**Rezoning Transportation Analysis**  
**Petition Number: Insert Zoning Petition # 2021-007**  
*General Location Identifier: Tax ID 08113110*

Revision Log:	Date	Description
	03-25-2021	First Review (WB)

SITE PLAN

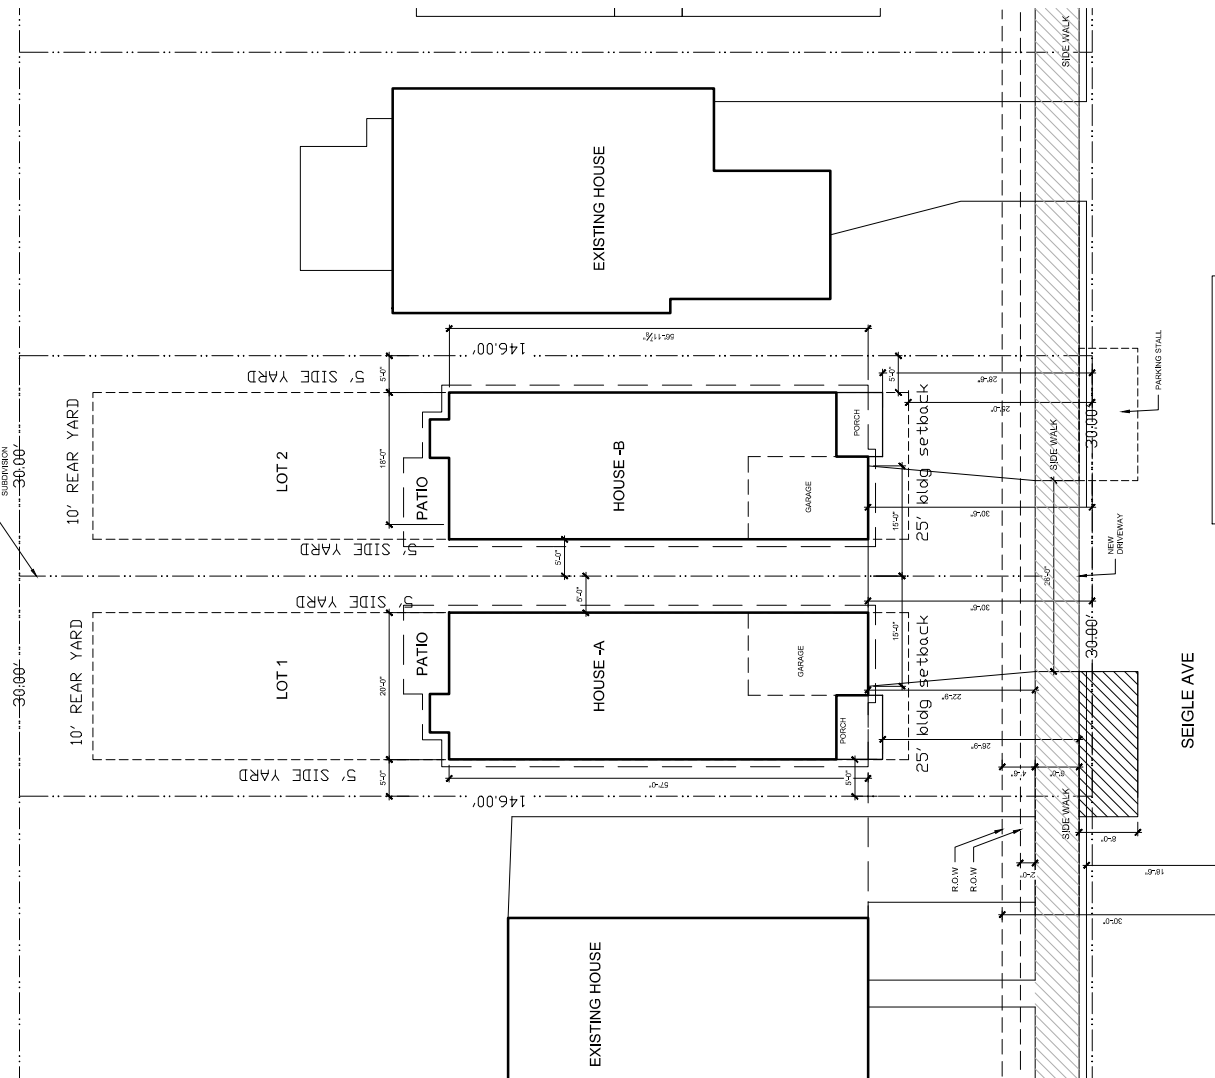
1. **Curblines:** The proposed zoning district has a setback measured from back of the existing or proposed future curblines.
  - a. **Seigle Avenue:** Location of curb and gutter needs to be constructed at 18.5' from the road centerline removing the existing on-street parking along the site's frontage.

Label and dimension the curb and gutter from the centerline for each road on the site plan.

3. Revise site plan and conditional note(s) to commit to dedicate 30' min right-of-way from the road centerline. The site plan shall label and dimension the right-of-way from the road centerline.

4. Revise site plan and conditional note(s) to commit to construct a 6-foot sidewalk, and an 8-foot planting strip on Seigle Avenue per Chapter 19. The site plan shall label and dimension both items from the back of curb and gutter and road centerline.

Reference CLDSM standard detail 11.09 for street typical.

5. Site plan and conditional note(s) revisions are needed to commit to construct 15' minimum Residential driveways per CLDSM 10.25A.

6. Add a site plan note specifying dedication and fee simple conveyance of all rights-of-way to the City before the site's first building certificate of occupancy is issued is needed. CDOT requests rights-of-way set at 2' behind back of sidewalk where feasible.
7. There are two on-street parking spaces located in front of property. Update the site plan to show the location of the on-street parallel parking spaces in front of the site on Siegle Avenue.
8. Add a site plan note specifying that all transportation improvements will be approved and constructed before the site's first building certificate of occupancy is issued is needed. The petitioner may phase transportation improvements if said improvements and phasing are explicitly described in site plan notes.
